From: kent lersch <kentlersch@kirellahomes.com>
Sent: Tuesday, November 24, 2020 12:22 PM
To: Judith Espinoza
Cc: Elizabeth Nijkamp; Brian and Julia; Jeff Rice
Subject: Re: 18755 Rockbrook Zoning Review Comments (SFD201631)

Elizabeth: Jeff Rice took a quick look at Plat 14293, and submitted BDA plot/site plan and architectural plan with me for this proposed residential build and concurred that the proposed architectural lower level plan and elevation plans did not satisfy requirements for plat note 20. Reference BDA Plan Set R137005, EDARP File SFD201631.

✓ SITE PLAN  
 18755 ROCKBROOK ROAD  
 BAXTER RESIDENCE  
 LOT 1, YARBROUGH SUB.

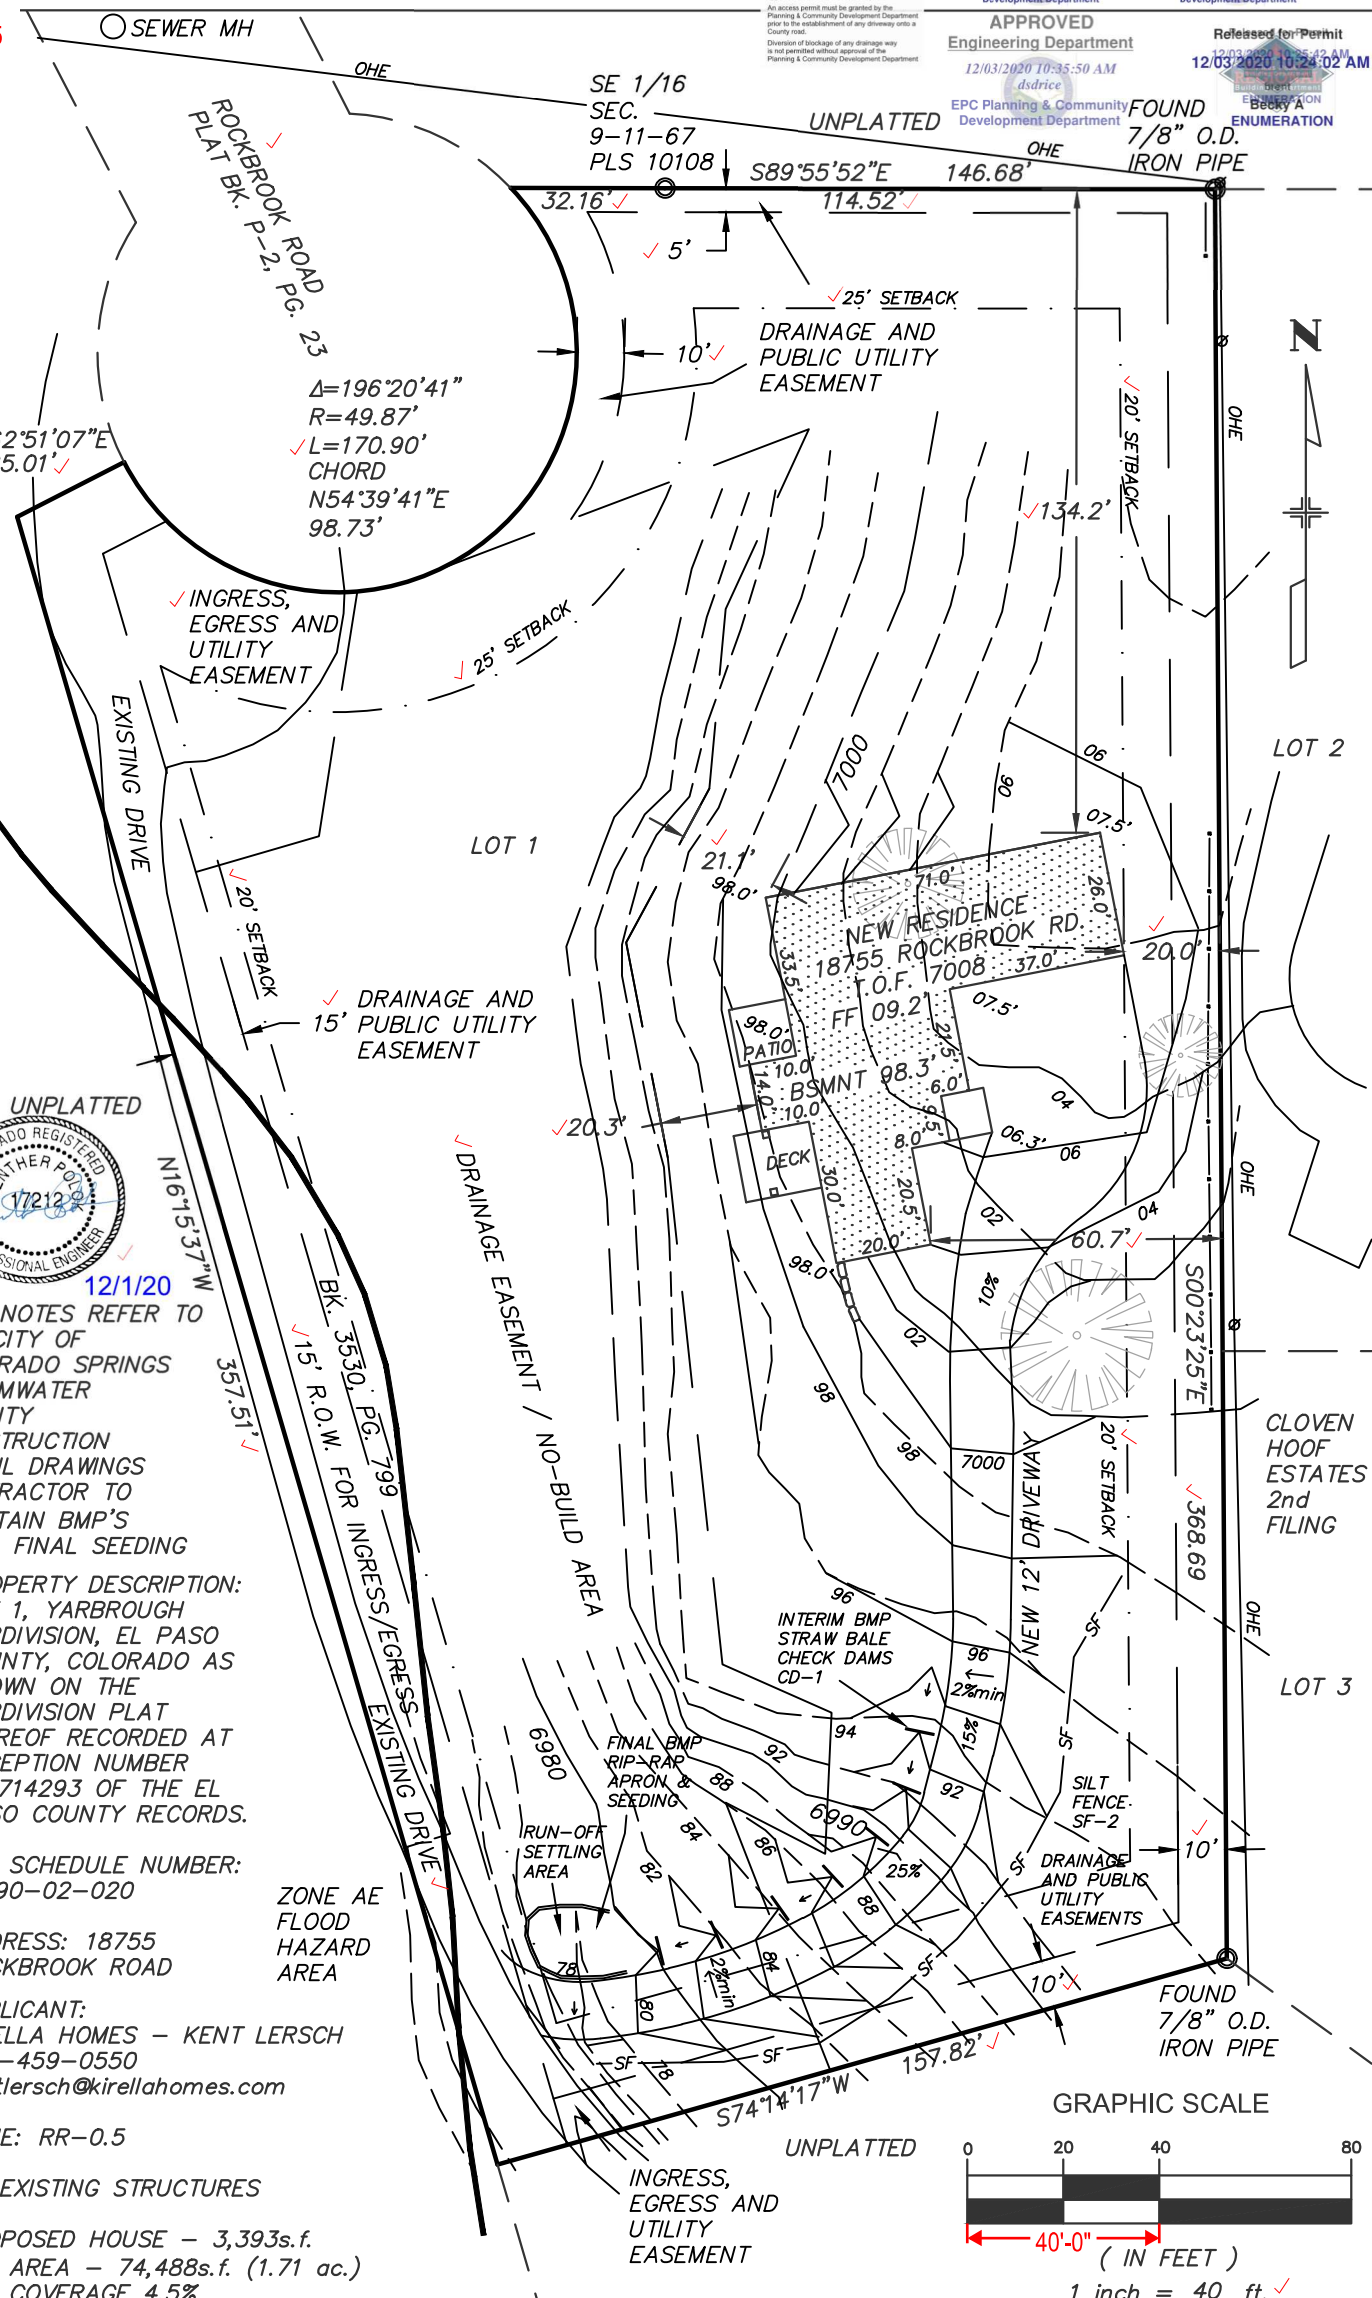
Thanks for looking into that for us. Jeff sent us an email yesterday letting us know that a foundation would be allowed on this property. I will be uploading the revised site plan shortly, for your review, with the two corrections- no structure within 20' of the no-build line and an engineer stamp.

Regarding Plat Note #17, it appears the submitted plot/site plan depicts the foundation of the proposed residential structure. The dimensional setback measurements 15'-10" and 13'-10" from the "no build" area to the structure depicted on the disapproved plot/site plan were based off the scale provided on the plot/site plan. Depict and denote the dimensional setback measurement from the closest point of the structure to the "no-build" area which shows the foundation outside the 20' setback to scale on resubmitted engineered stamped plot/site plan. Enclosed for your reference is the current Land Development Code for Section 5.4.3.(E) Projections into Setbacks. This should address your concerns regarding roof overhangs.
